DATE January 31, 2024

Project No. 21482114

**RESPONSE TO GEOTECHNICAL PEER REVIEW COMMENTS FROM GEMTEC
PROPOSED RESIDENTIAL DEVELOPMENT
3930 AND 3960 RIVERSIDE DRIVE, OTTAWA, ONTARIO**

PROJECT NO.	CONTROL	REV.	FIGURE
21482114	0005	A	1A

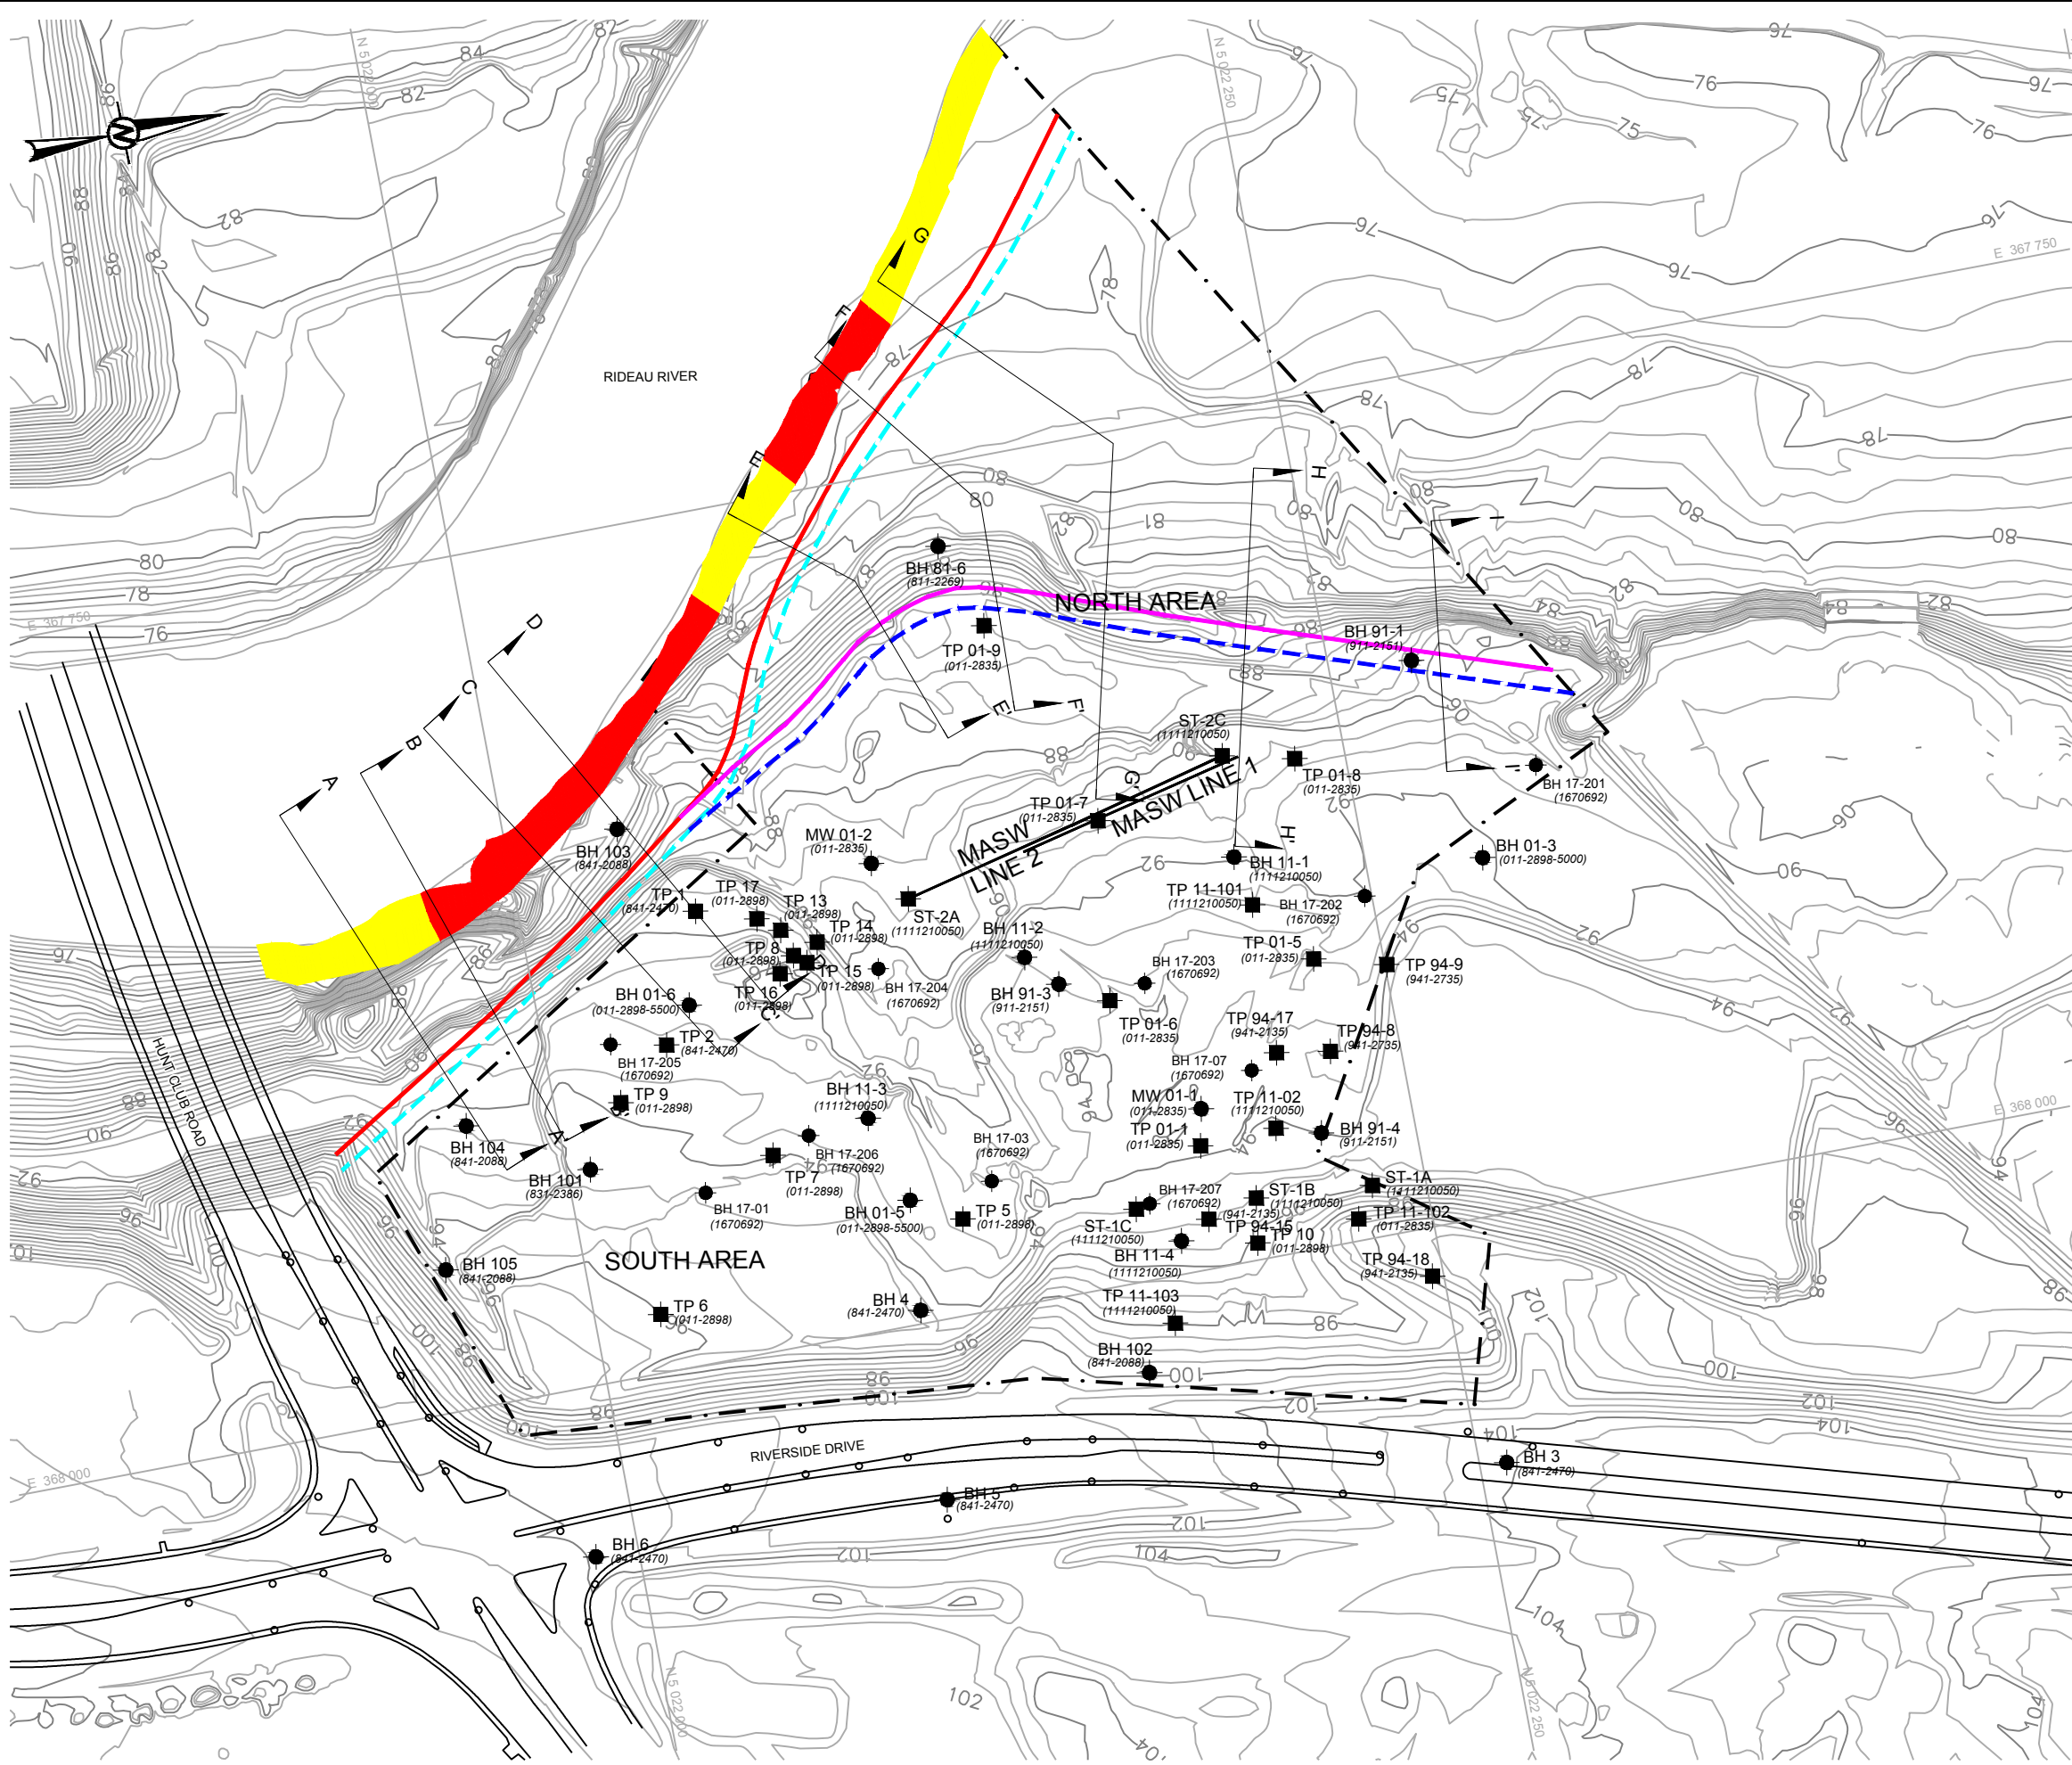
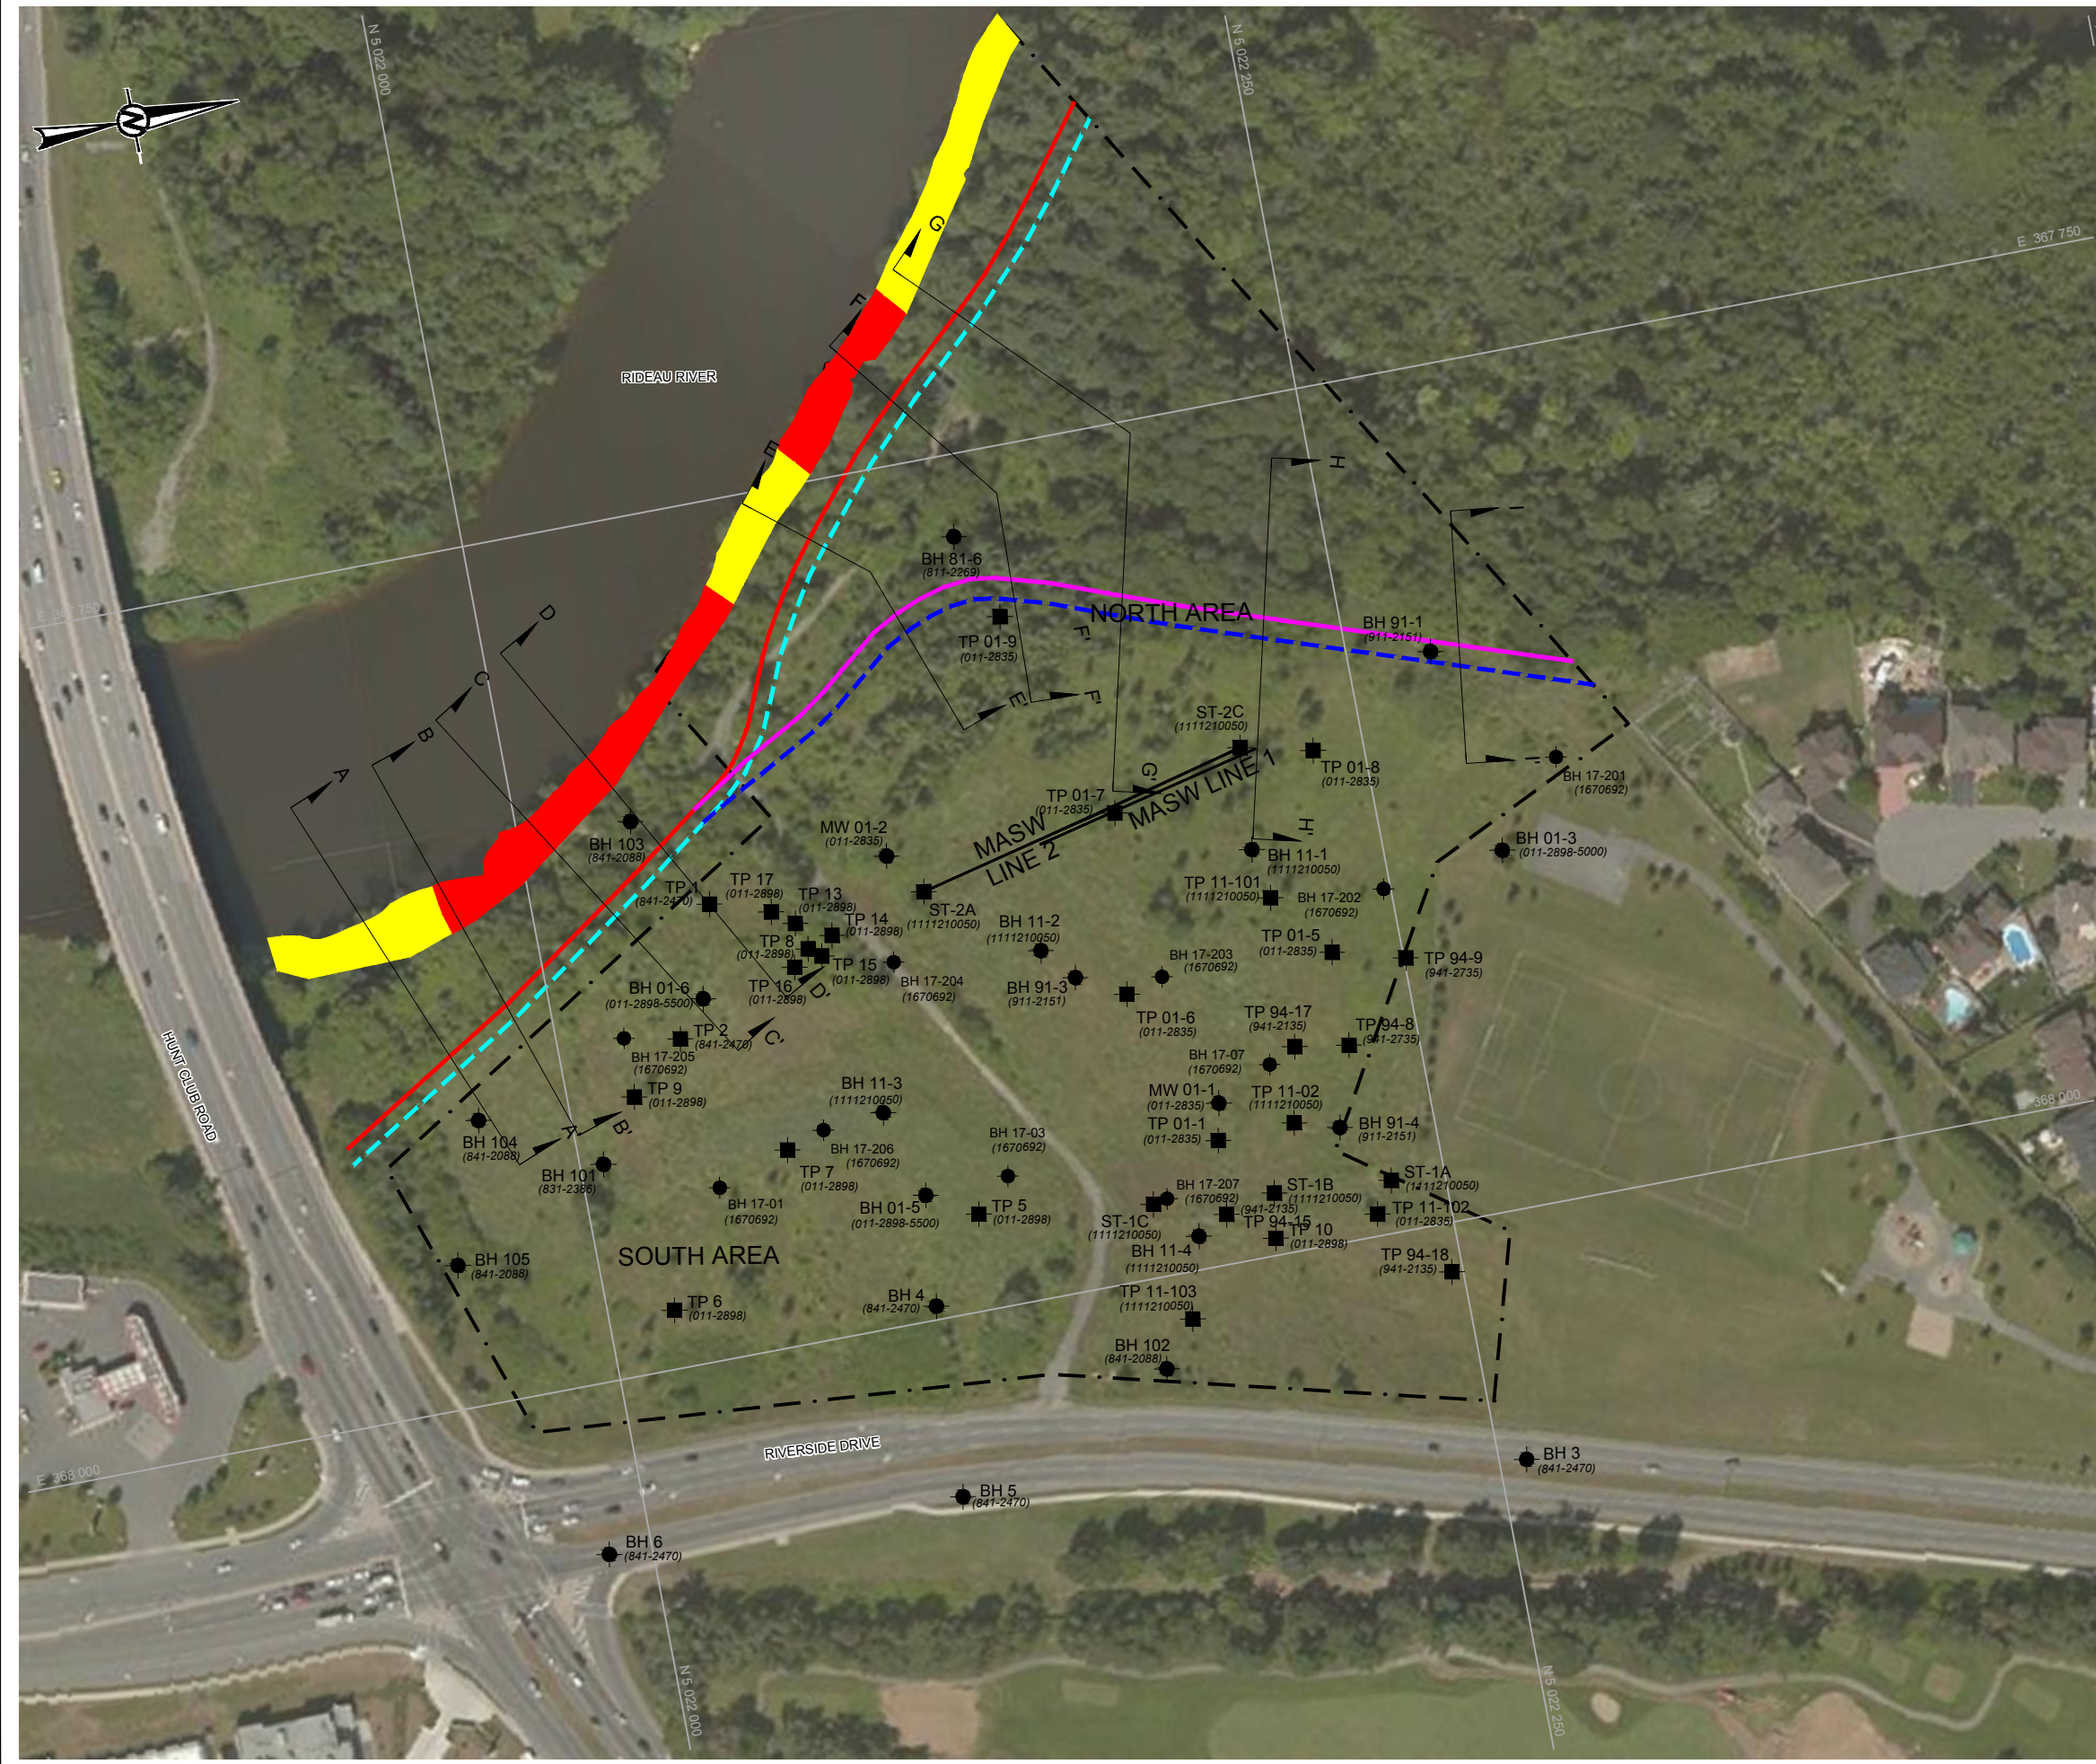
- 1) "The site plan in the report (i.e., Figure 1) indicates the locations for the following test pits or borehole but the records do not seem to be included in the report.
 - Testpits 1 to 17 (Project No. 011-2898);
 - Testpits 94-15 and 94-18 (Project No. 941-2135);
 - Testpits ST-1A, ST-1B, ST-1C, ST-2A, ST-2C (Project No. 1111210050); and,
 - Boreholes 3, 5, and 6 (Project No. 841-2470)"

- 2) "In addition, the following was also noted with respect to the testhole records and site plan:
 - TP 11-102 (011-2835) and TP 11-02 (1111210050) seem to be mis-labelled; and,
 - There appears to be an unlabelled testpit marker in the area between BH 91-3, CPT23-02/02B/02C, and 17-203 (approximately in the middle of the site)."

- 3) "The MASW testing was carried out within the North Area, where the fill thicknesses are significantly less than in the South Area (i.e., 6 to 7 metres at the MASW lines versus up to 20 m thickness in the South Area). Due to the significant difference in stratigraphy, it is not clear that the obtained shear wave velocity values are representative within the South Area or that the interpreted Site Class D based on those values is also applicable for the South Area. "

Response - *The above noted records could not be located in our archives and have therefore not been included in the report. The locations of these boreholes and test pits have also been removed from the site plan for clarity.*

Response - *The above has been corrected on the site plan.*

Response – *Additional MASW testing within the South Area was carried out by Conetec on 2 March 2023 (See Appendix G of the WSP report). The results are consistent with a Site Class D. This MASW line has now been added to the Site Plan (Figure 1).*
